From: Laura Gibbons
Sent: 30 July 2018 10:14
To: Planning.Responses
Subject: RE: Planning Consultation on BN/35/18/DOC

Engineers Comments Regarding Conditions 5 and 6

APPLICATION **BN/35/18/DOC**
NO:

Registered: 29-JUN-18
Site Address: Land at former Pollards Nursery Lake Lane Bognor Regis

Ditch Filling Detail

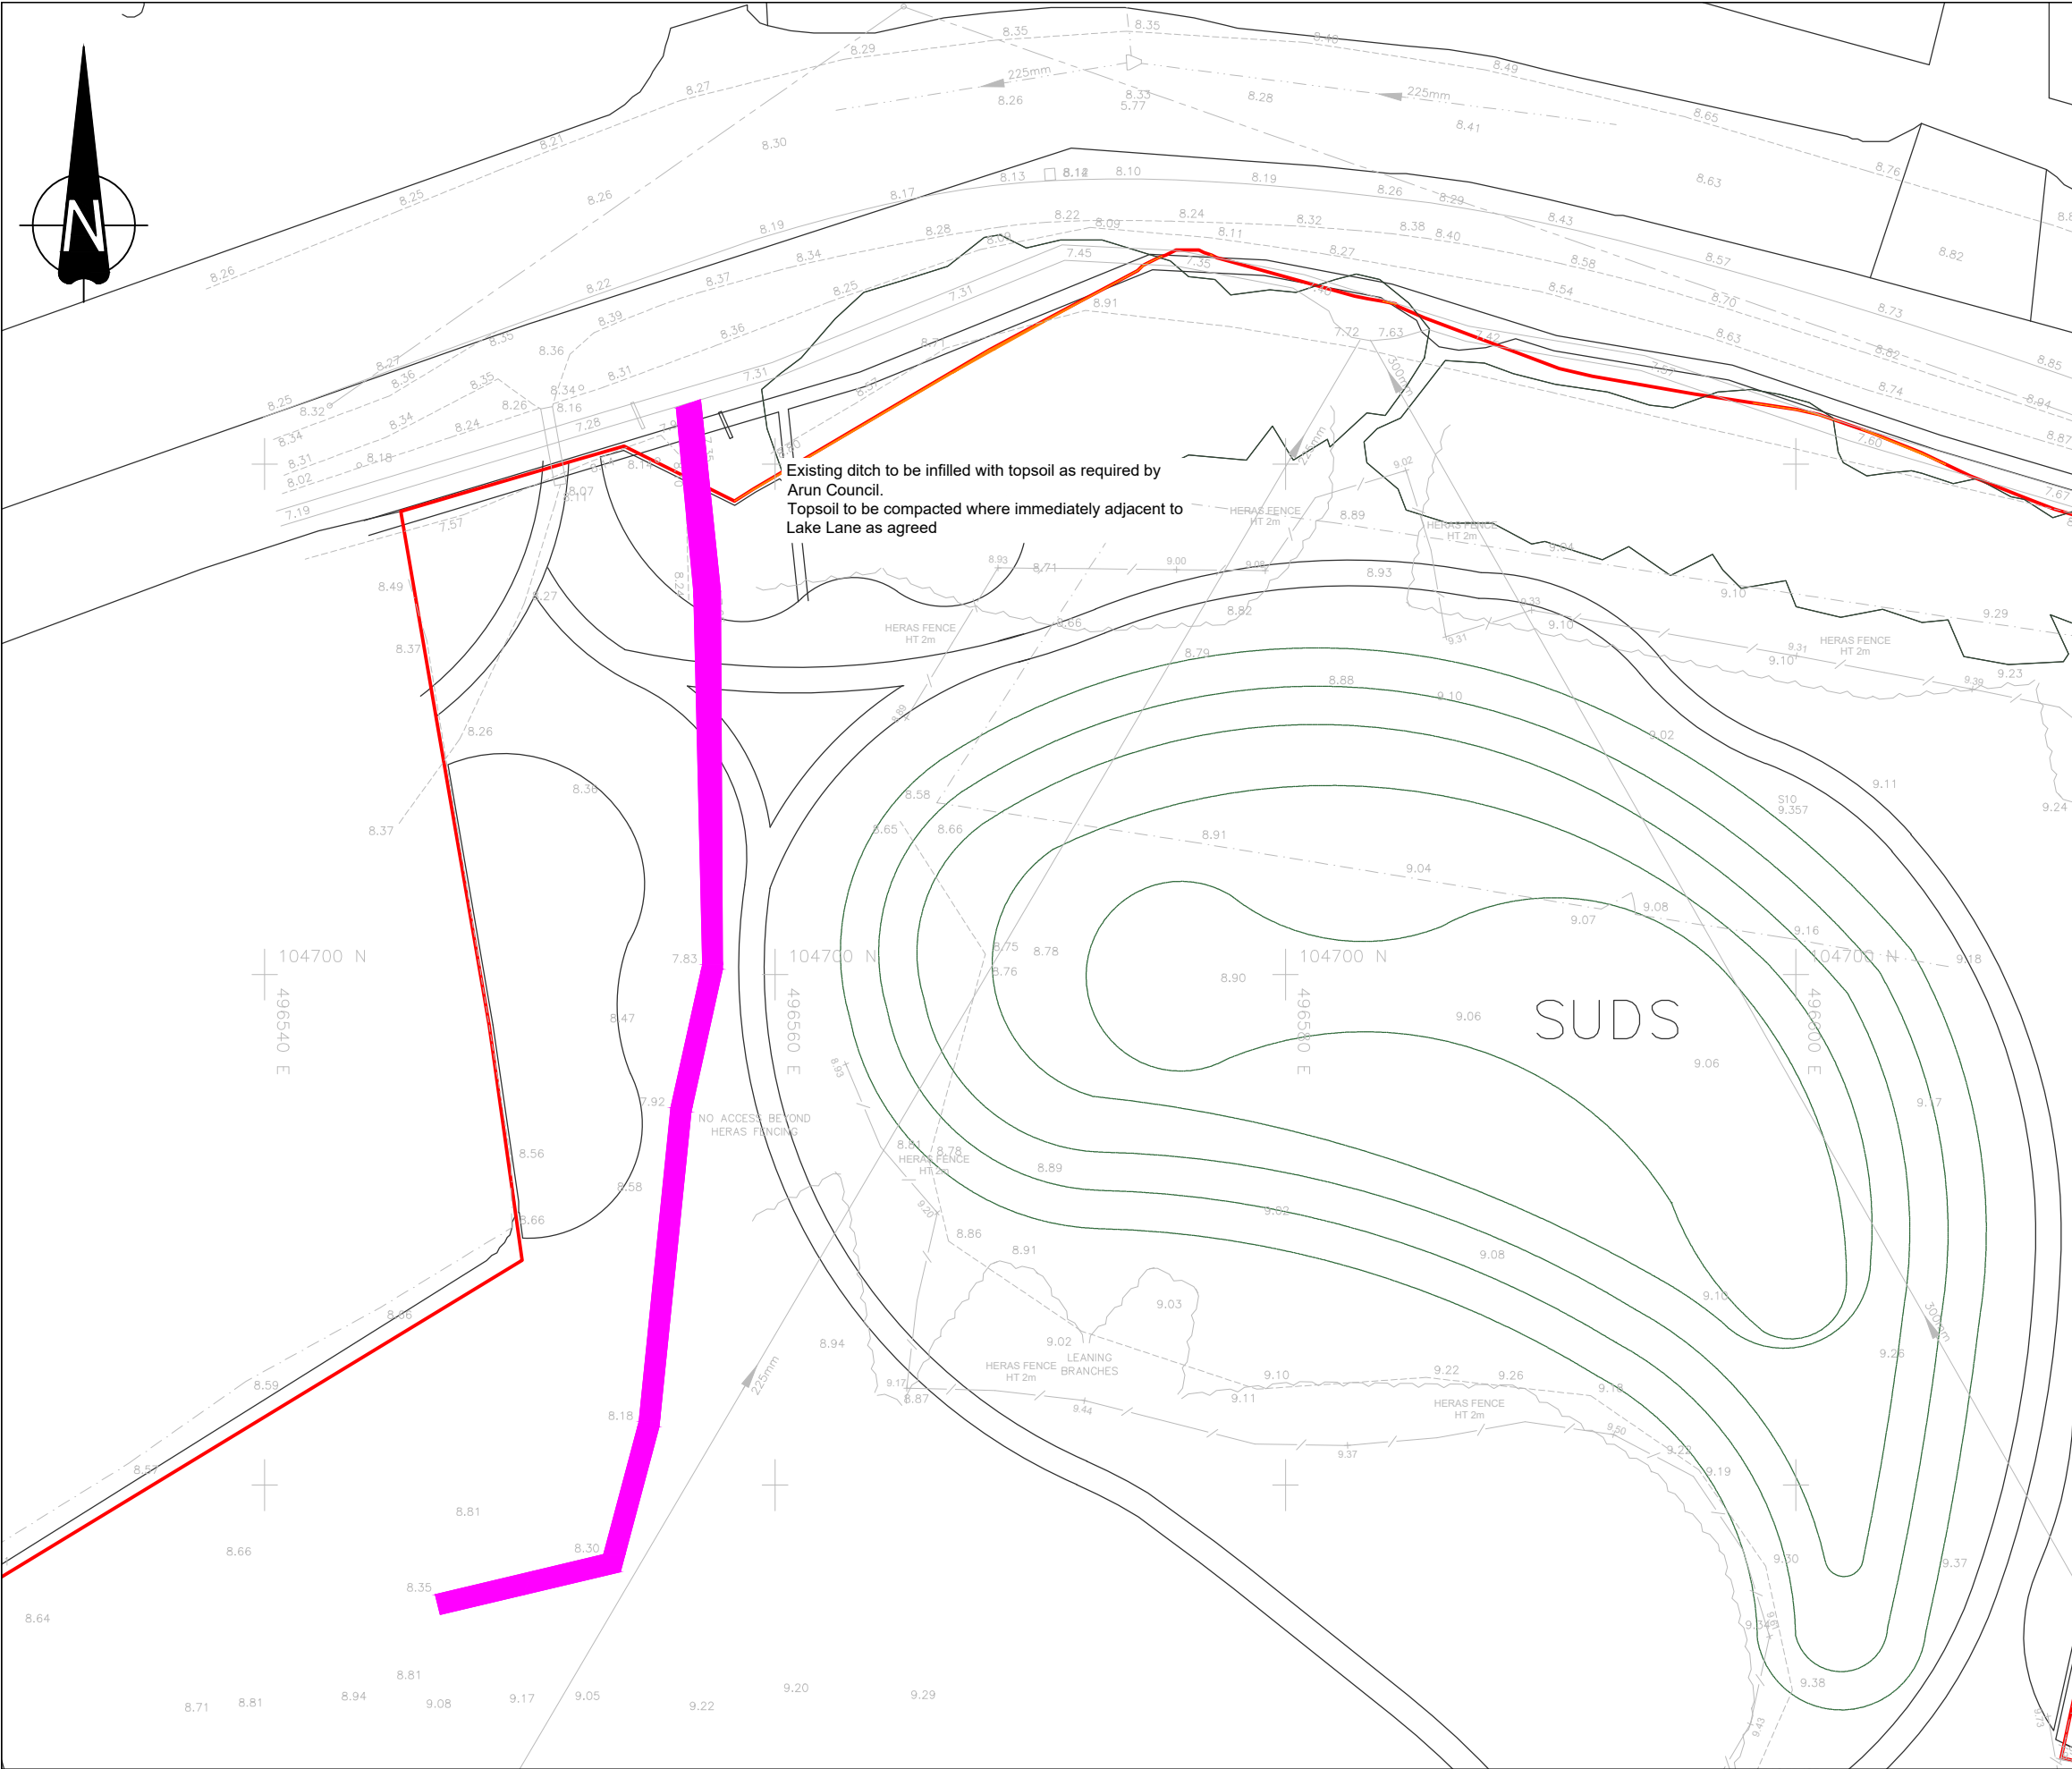
The provided details are acceptable. However no details regarding the abandonment of the redundant ditch have been supplied. Please supply these to meet requirements as discussed with Paul Cann last week. I will review these details before recommending the conditions are discharged.
